CITY OF PORTLAND

BUILDING PERMIT

Job ID: 2012-02-3242-DRG

has permission to Construct detached garage

18' X 30' GARAGE

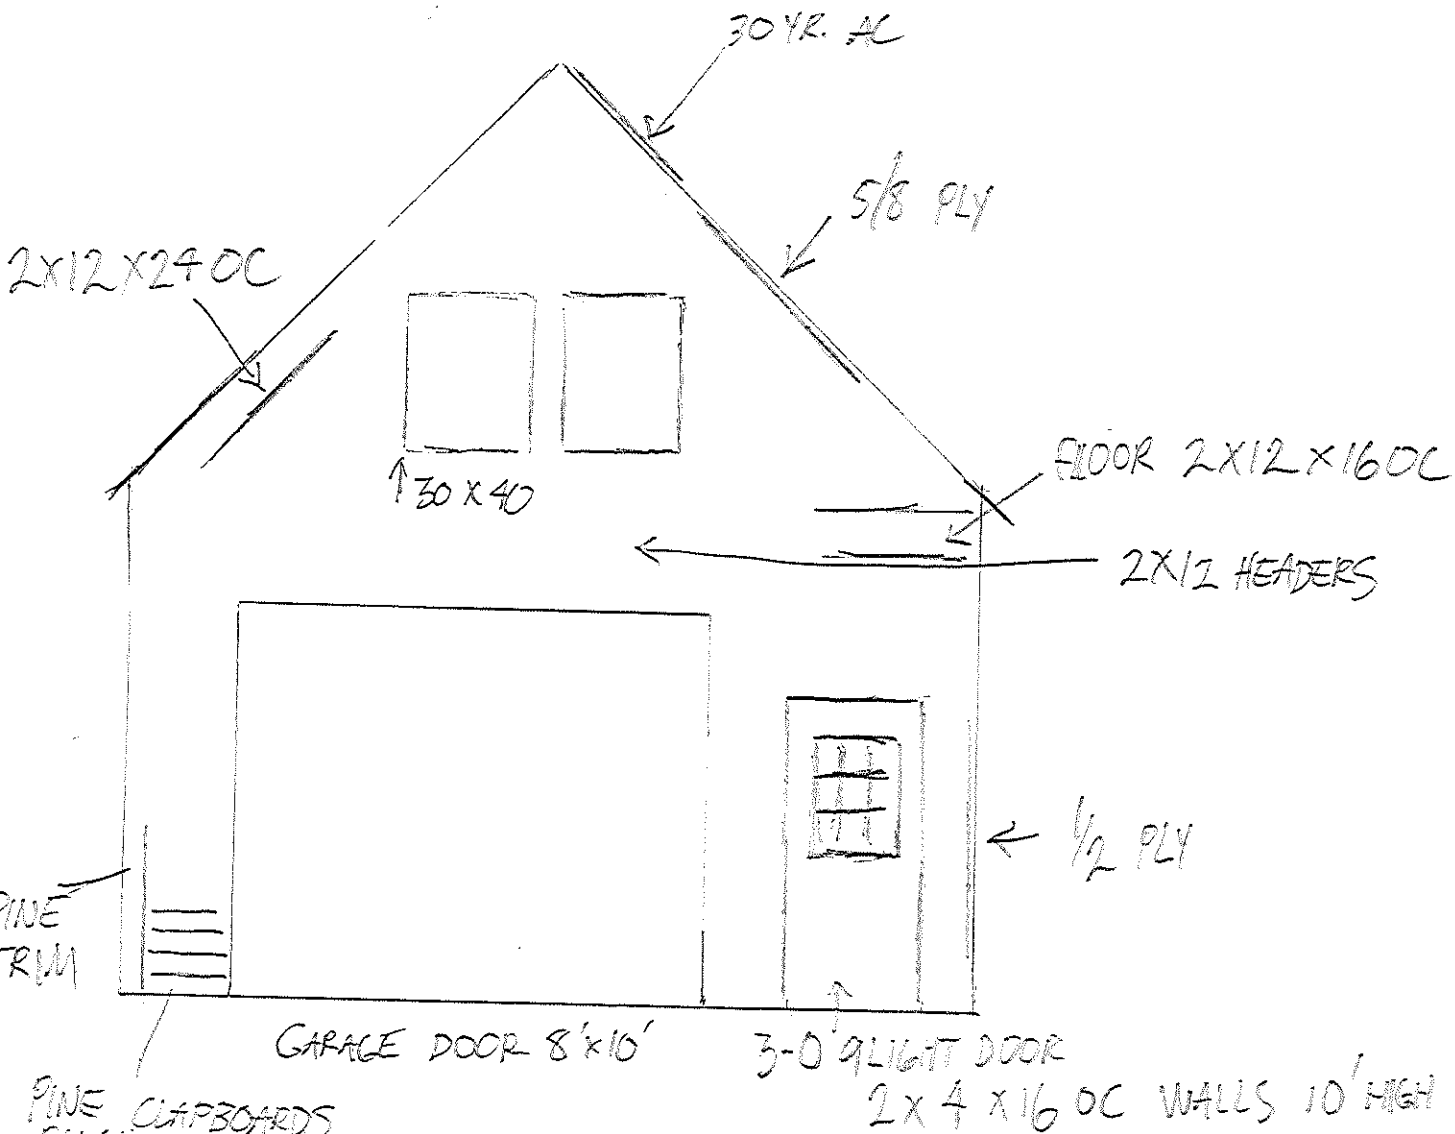
1. This permit is being approved on the basis of plans submitted. Any deviations shall require a separate approval before starting that work.
2. As discussed during the review process, the property must be clearly identified prior to pouring concrete and compliance with the required setbacks must be established. Due to the proximity of the setbacks of the proposed addition, it may be required to be located by a surveyor.
3. This property shall remain a single family dwelling. Any change of use shall require a separate permit application for review and approval.
4. It is understood that the ½ story above the garage will NOT be used for habitation and is only for the storage of materials

1. Separate permits are required for any electrical, plumbing, sprinkler, fire alarm HVAC systems, heating appliances, commercial hood exhaust systems and fuel tanks. Separate plans may need to be submitted for approval as a part of this process.
2. Application approval based upon information provided by applicant. Any deviation from approved plans requires separate review and approval prior to work.
3. There must be a 36" high guardrail enclosing the stairs with balusters spaced maximum 4"oc and with a graspable handrail.
